**Colorado's Power Pathway – Xcel Energy Responses to El Paso County Referral Comments**

ATTACHMENT F: LAND USE AND ZONING MAP

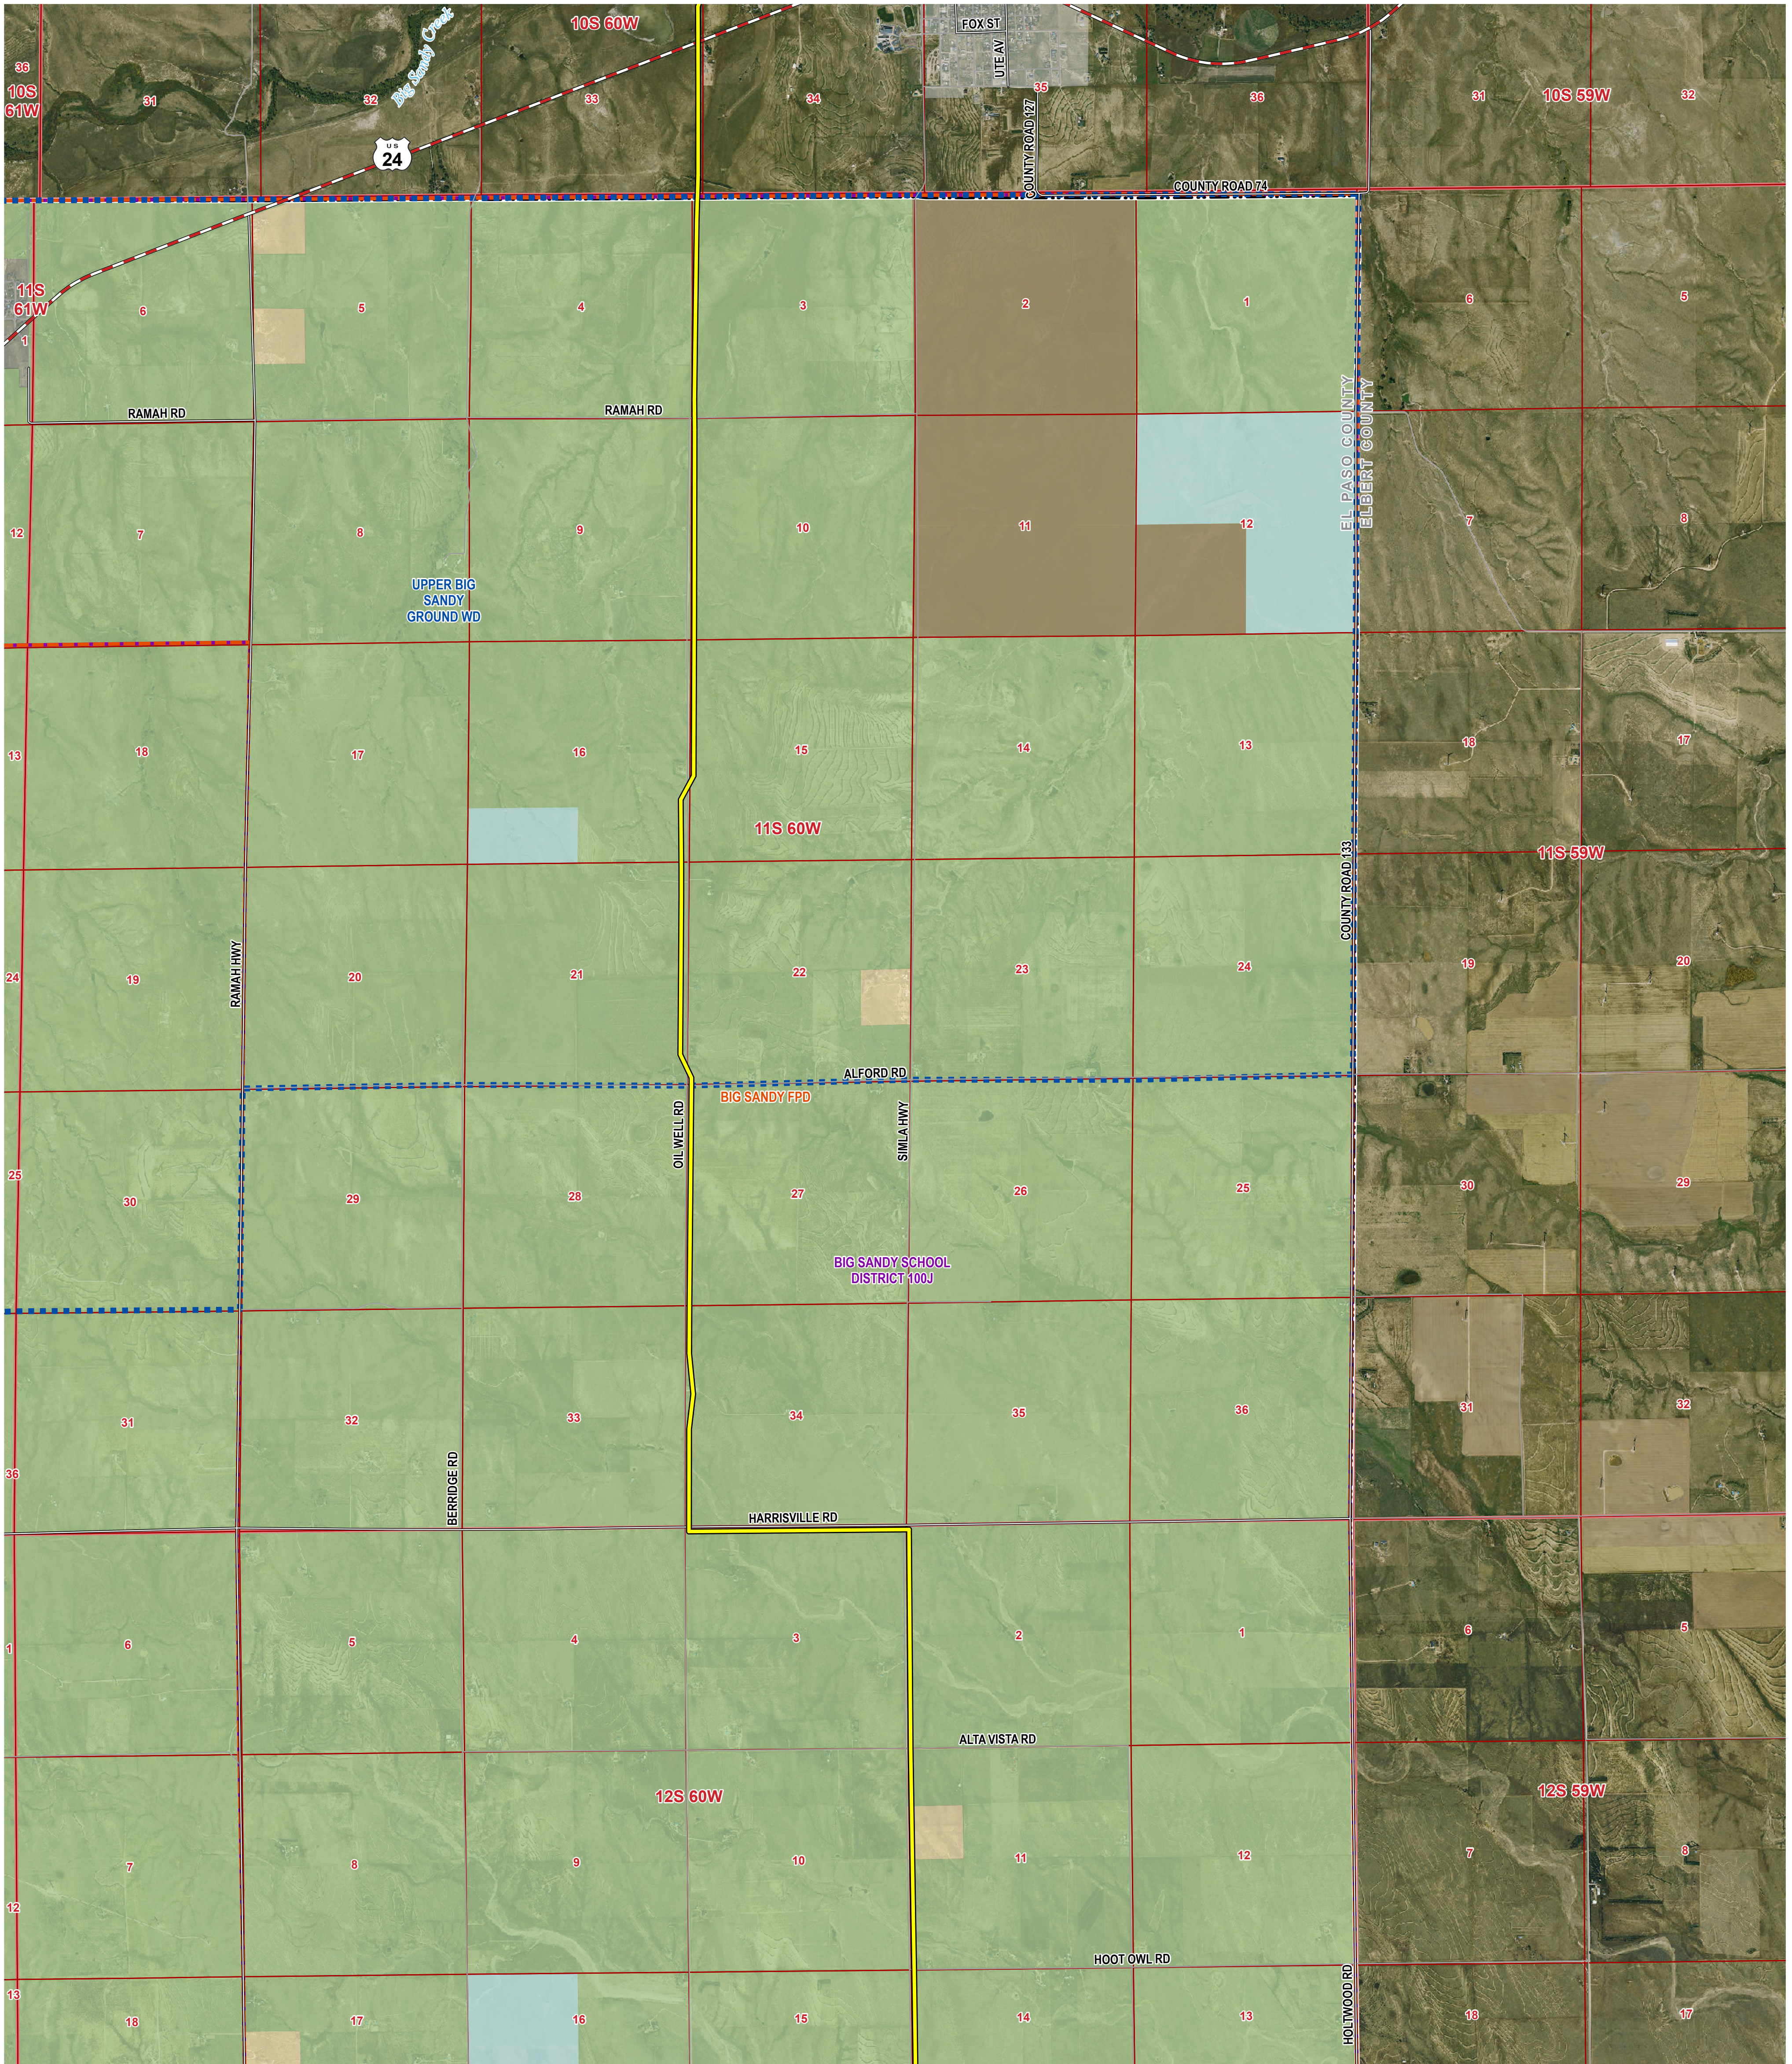
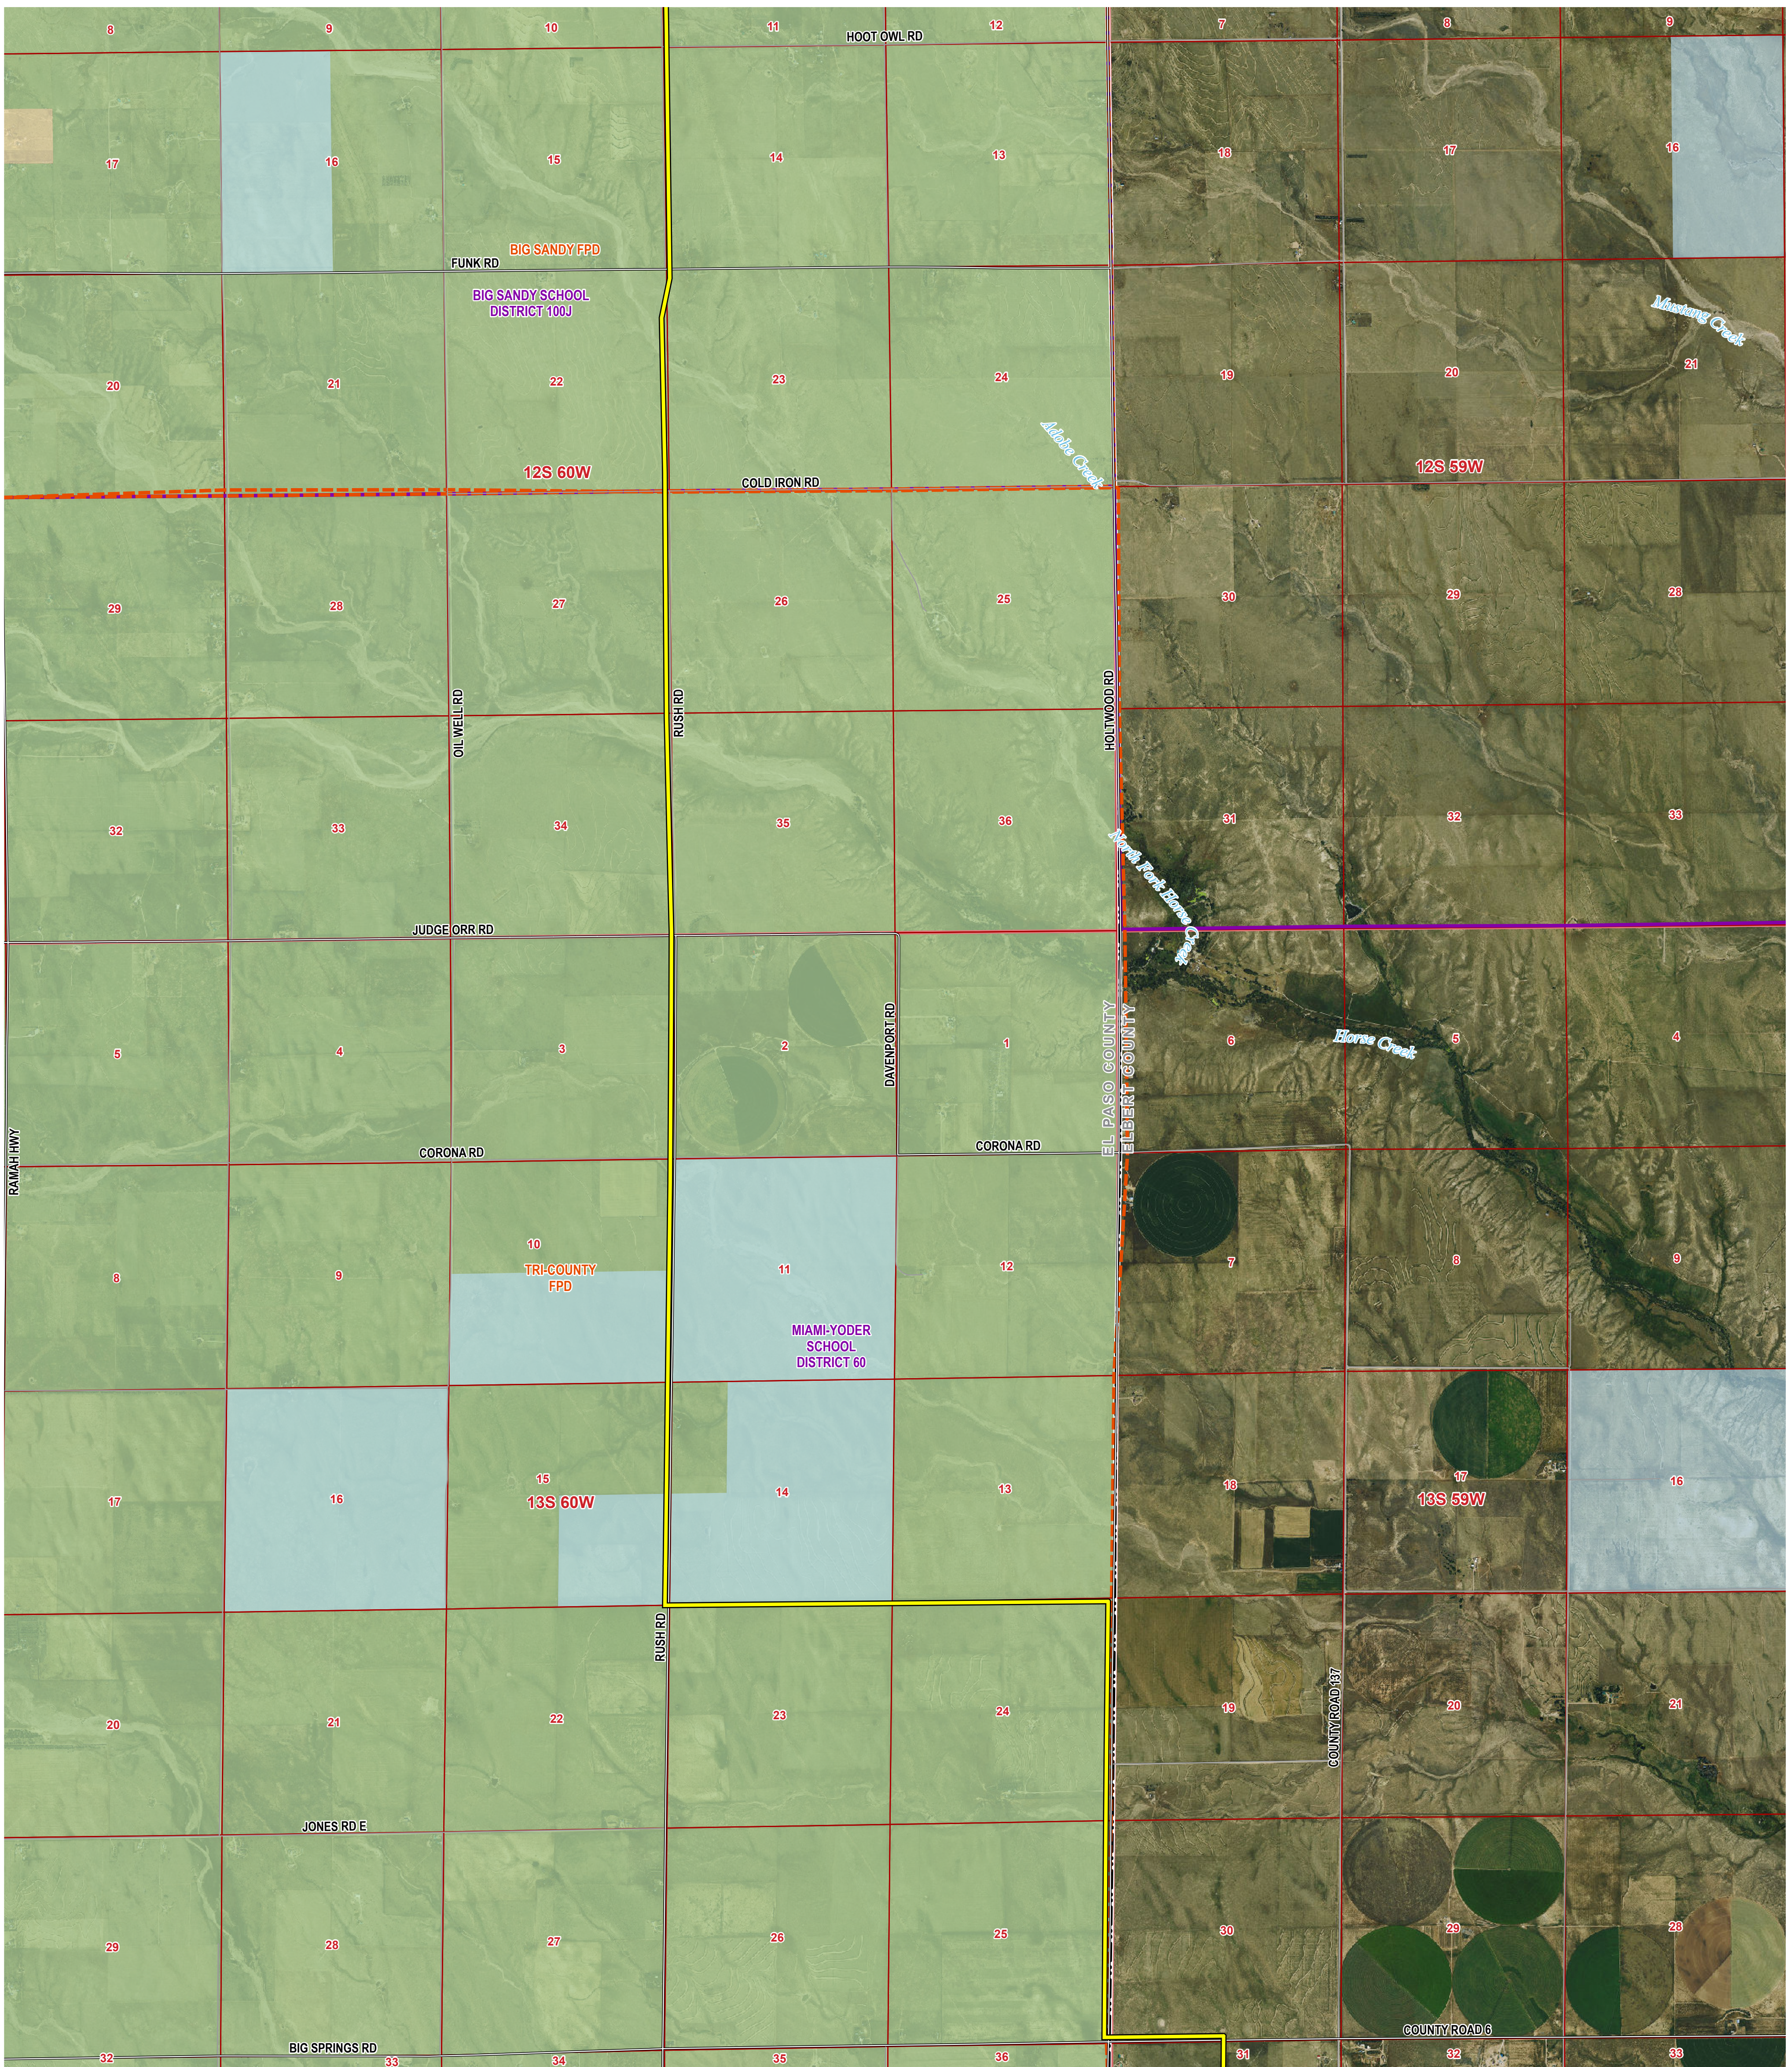
1. You have provided a zonemap- Please add a symbol or label of land use- is land adj to line vacant; has residence; commercial business- the land use is not identified in the exhibit.	The Land Use and Zoning Map has been revised to indicate adjacent land uses. The revised Land Use and Zoning Map is provided as Resubmitted Attachment F.
<b>PCD Project Manager_2024-08-19_Comment.txt</b>

1. Zoning and Land Use Map- No land-uses were shown.	The Land Use and Zoning Map has been revised to indicate land uses. The revised Land Use and Zoning Map is provided as Resubmitted Attachment F.
<b>PCD Project Manager_2024-08-19_003.pdf</b>	
Attachment I: Transportation Memorandum 1. See comments on Haul Route Plan and update accordingly	The Revised Transportation Memorandum has been updated to address comments received in the following documents: <ul style="list-style-type: none"> <li>• El Paso County PCD – Project Manager_2024-08-19_004</li> <li>• Colorado Department of Transportation - Pueblo Office_2024-07-18_Comment</li> </ul> The Revised Transportation Memorandum is provided as Resubmitted Attachment I.
<b>PCD Project Manager_2024-08-19_003_Comment.txt</b>	
Traffic impact Study Comments	The Revised Transportation Memorandum has been updated to address comments received in the following documents: <ul style="list-style-type: none"> <li>• El Paso County PCD – Project Manager_2024-08-19_004</li> <li>• Colorado Department of Transportation - Pueblo Office_2024-07-18_Comment</li> </ul>
